Application No.: 21/03267/OUT

Proposal: Outline planning permission (all matters reserved except for access) for the erection of buildings comprising logistics (Use Class B8) and ancillary Office (Use Class E(g)(i)) floorspace and associated infrastructure; construction of new site access from the B4100; creation of internal roads and access routes; and hard and soft landscaping

Location: OS Parcel 0006 South East Of Baynards House Adjoining A43, Baynards Green

Berkshire, Buckinghamshire and Oxfordshire Wildlife Trust

Drawing Title: **PARAMETER PLAN 08
VEGETATION RETENTION
& REMOVAL**

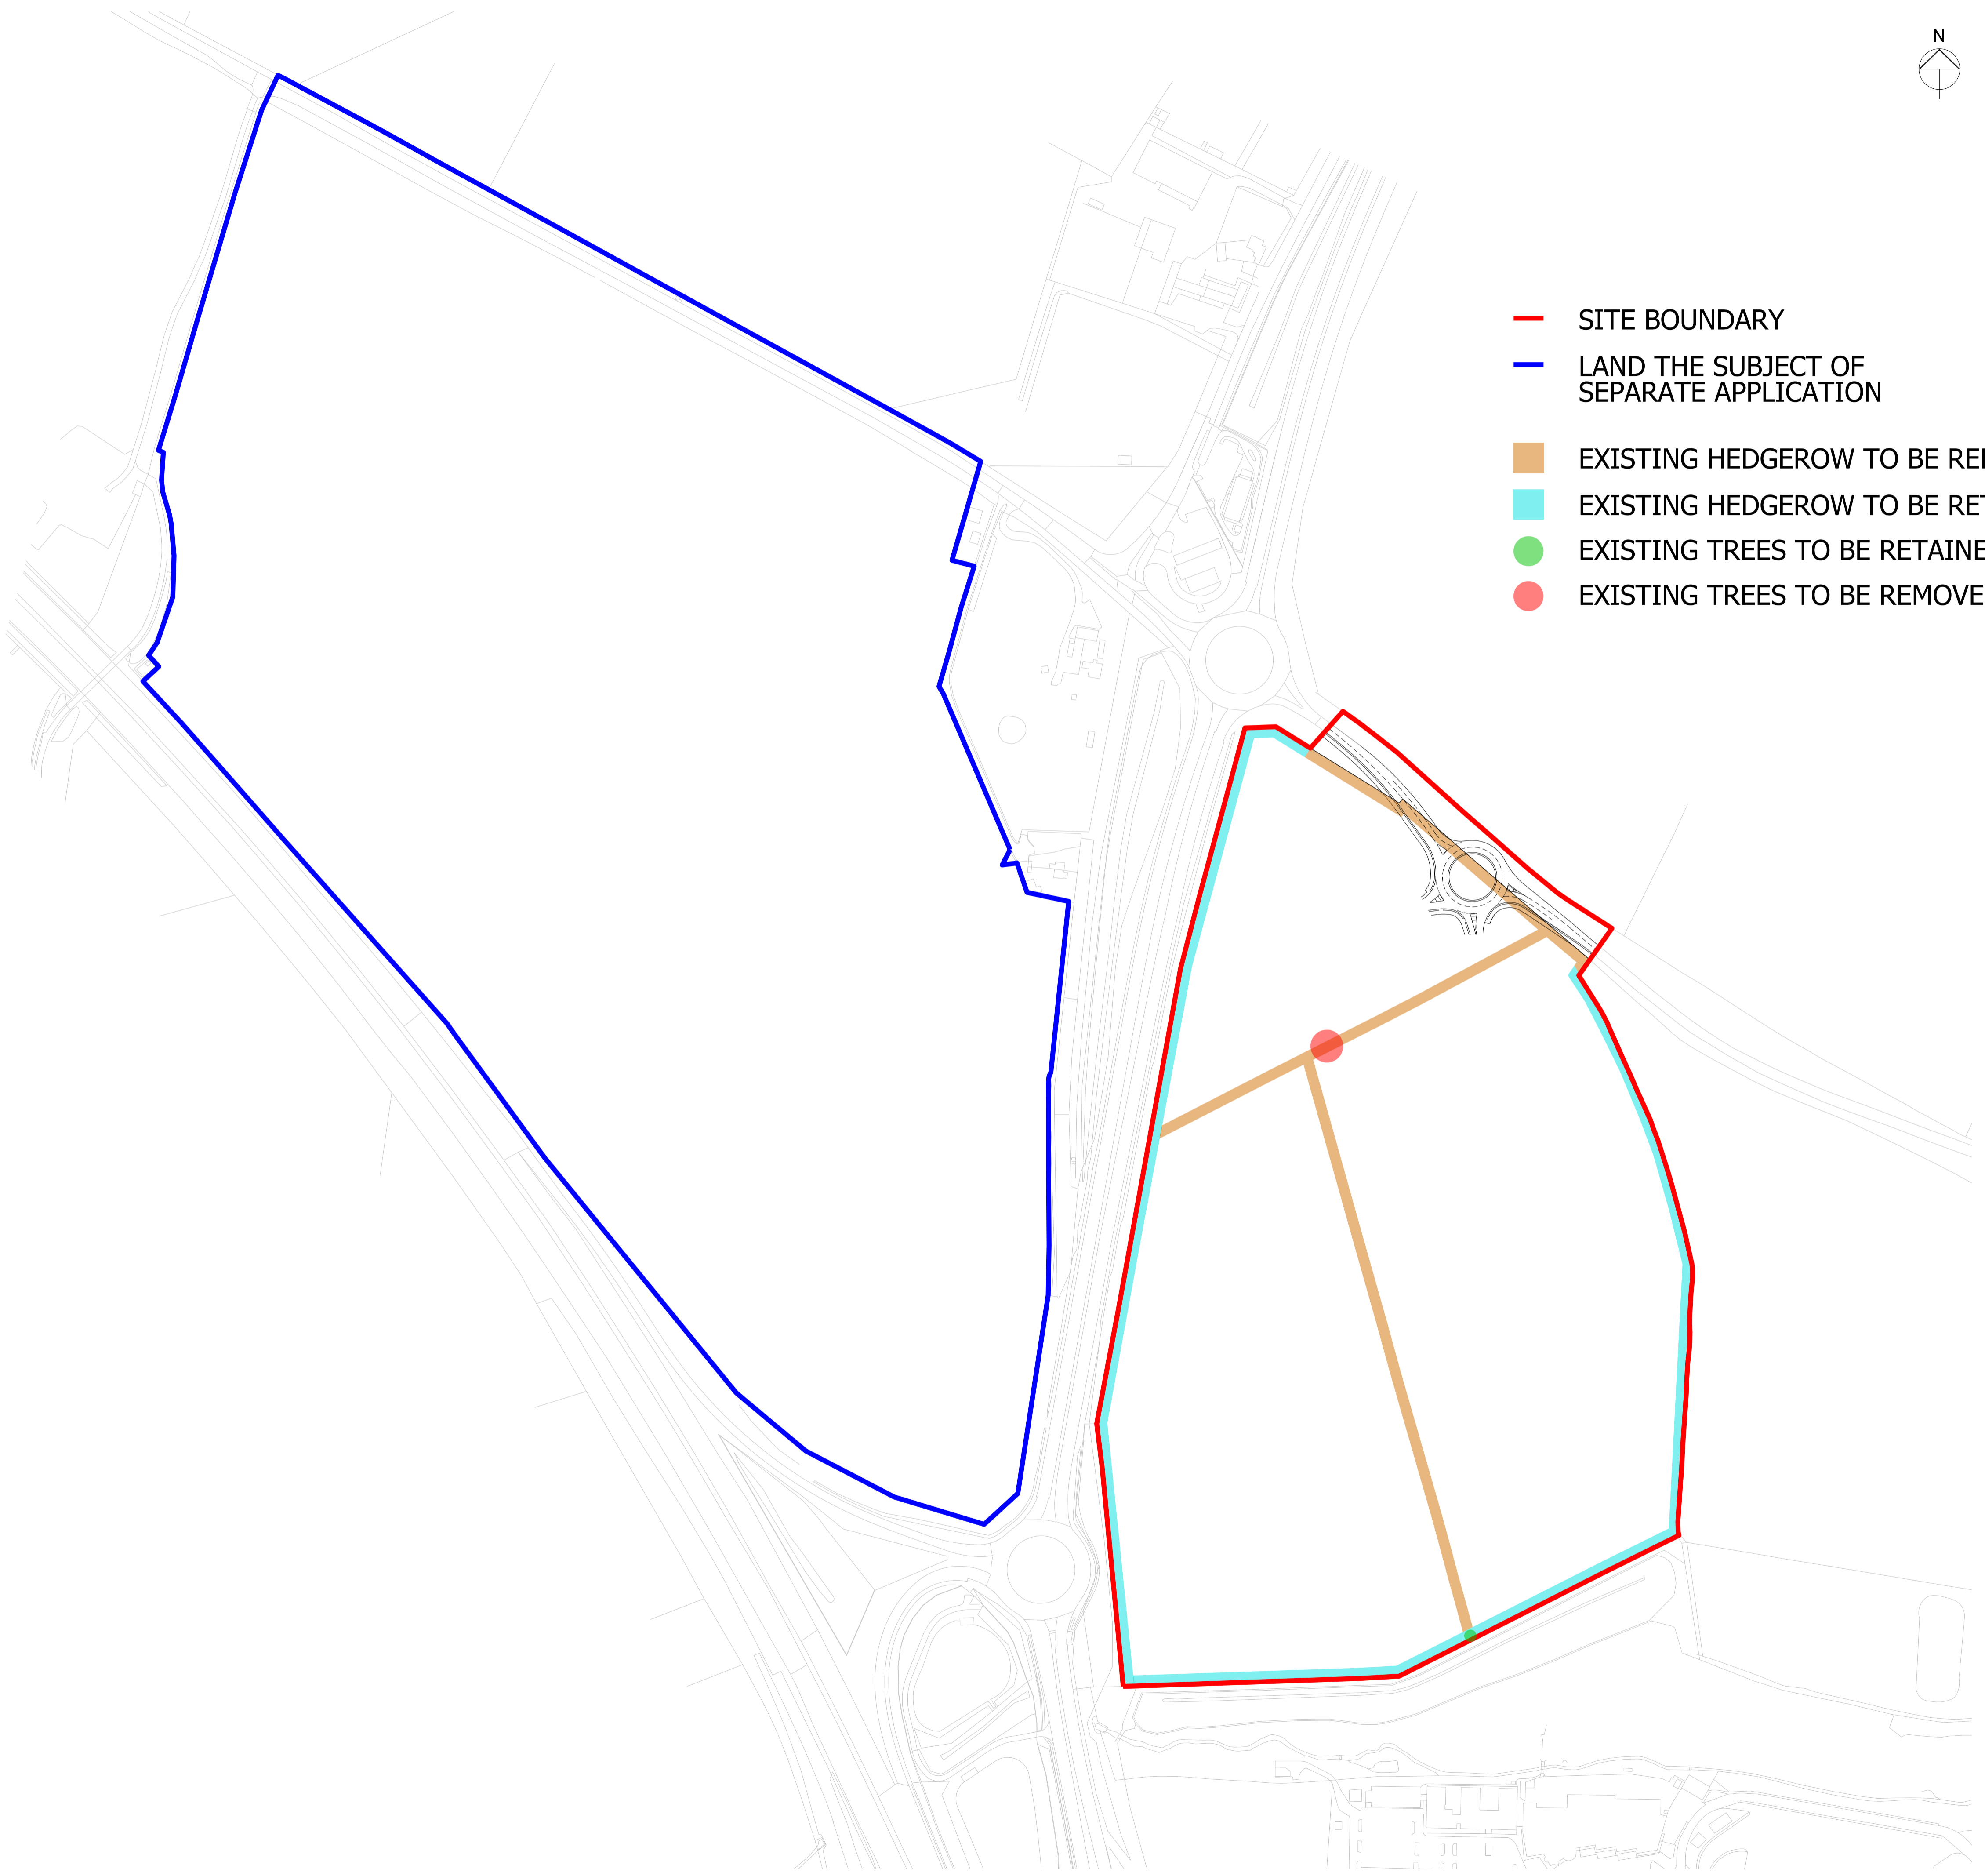
As stated in our previous response we are greatly concerned by the loss of hedgerow priority habitat that this development would lead to. We note that the applicant will retain some of the hedgerow and replace some of it onsite. In addition, hedgerow is to be created off site at Piddington resulting in a net gain in hedgerow habitat.

It is essential that the hedgerows are retained and managed to a very high standard in perpetuity in order to compensate for the permanent loss of hedgerow habitat onsite (see point 3 below).
